MEMORANDUM

SUBJECT: SF-18-008 – Lorson Ranch East Filing No. 1
Third Submittal-response

**POND C5
FOREBAY 'A' AND 'B'
LAYOUT AND DETAILS**

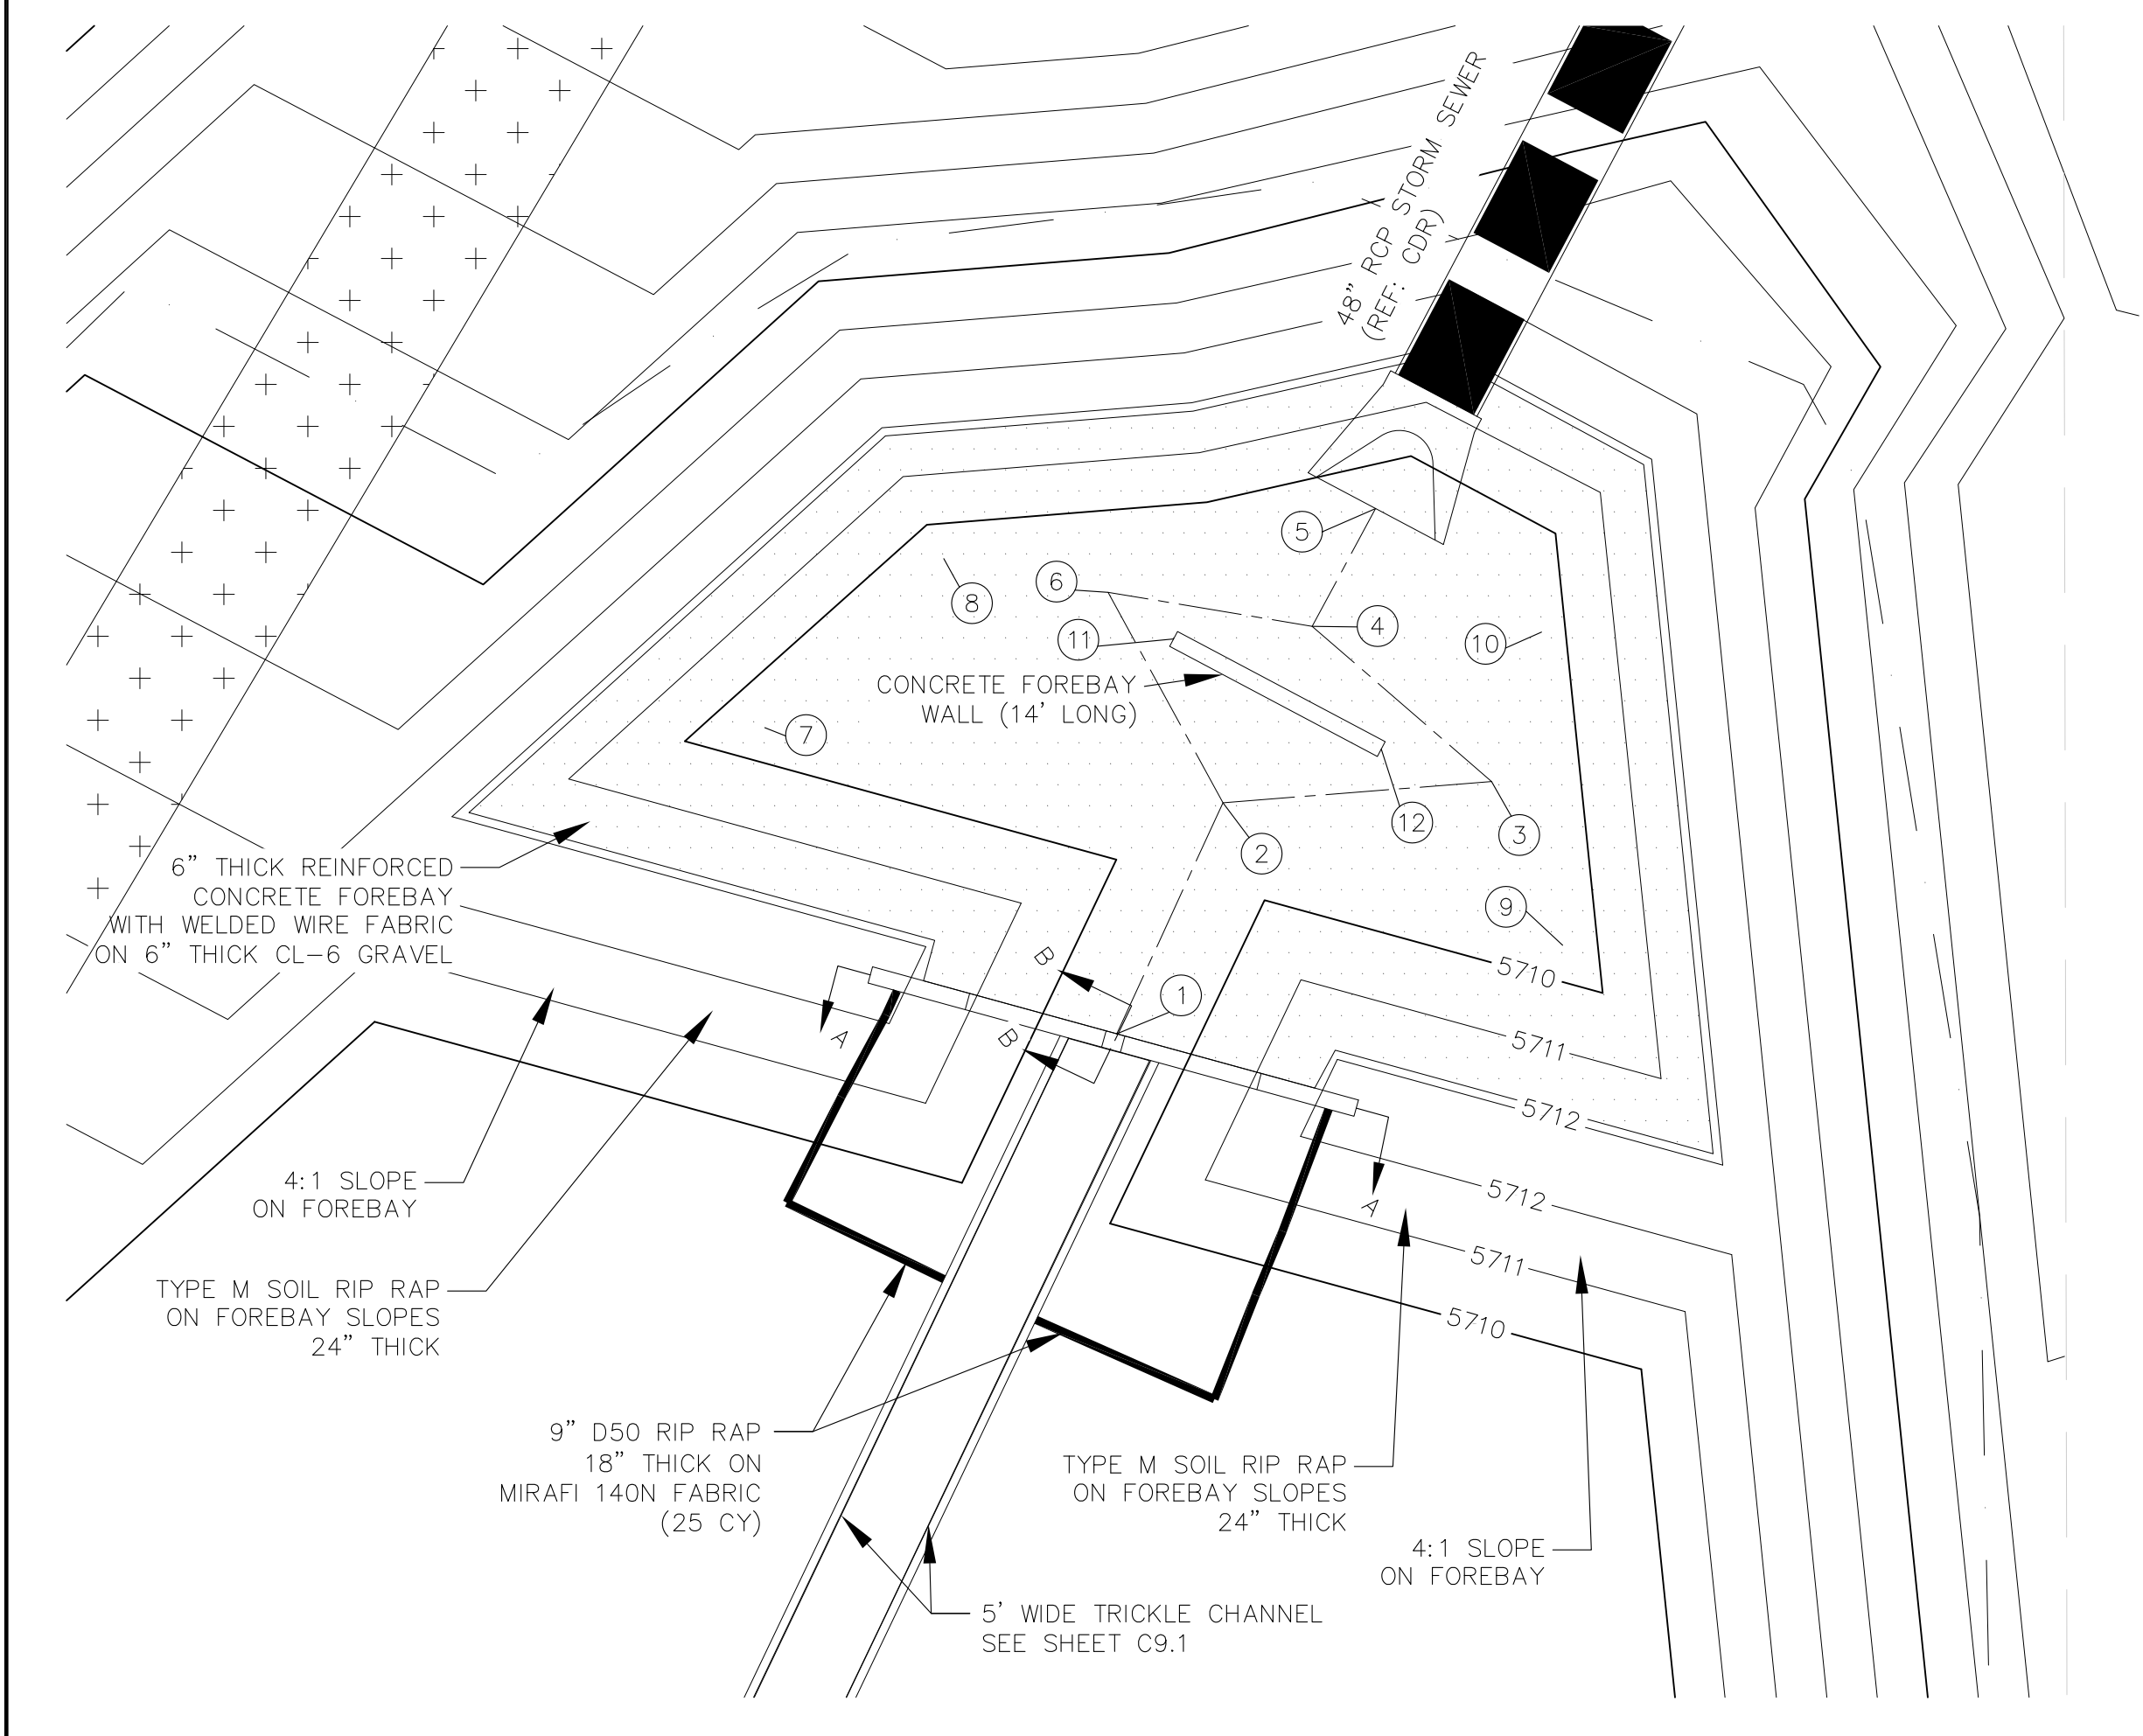
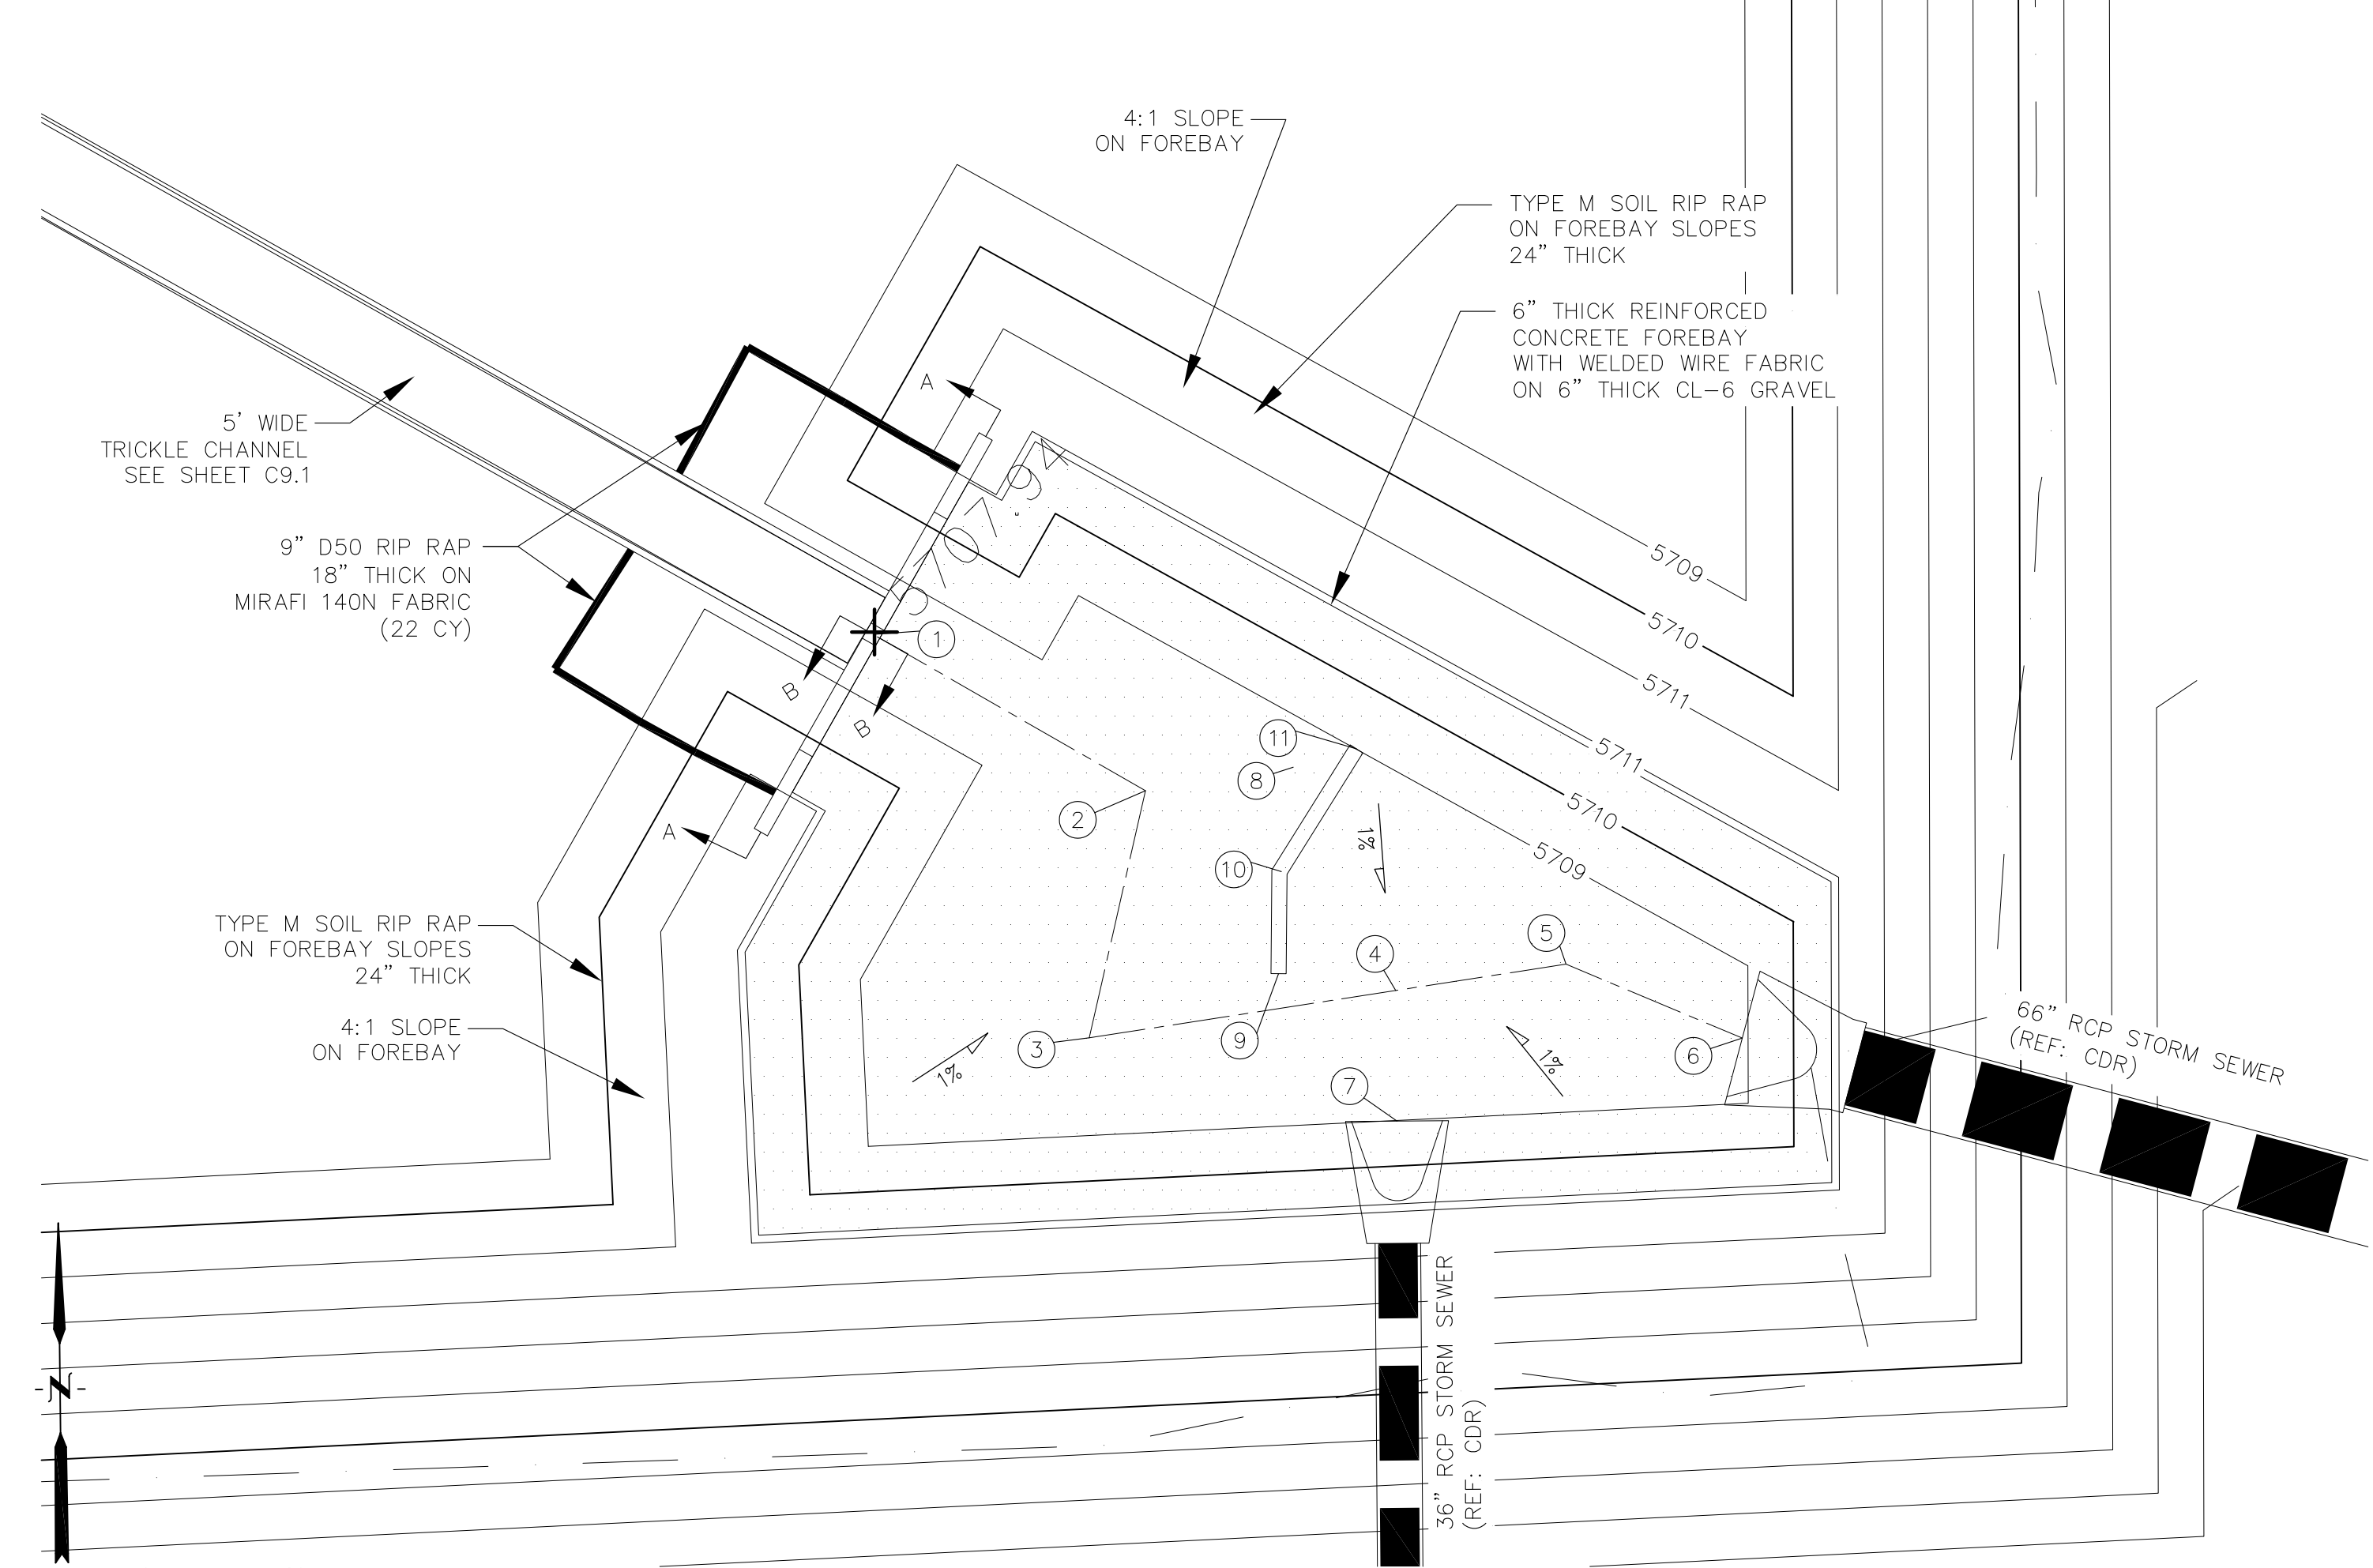
1. **Resolved**
2. Resolved
3. Detention pond narrative and calculations need to address both interim (undeveloped upstream with no ponds) and ultimate future conditions. Include estimated school site pond design in series to ensure proper Pond C5 functions. Partially resolved; see redlines. If the school site detention outflow affects Pond C5, revisions to Pond C5 may be needed.
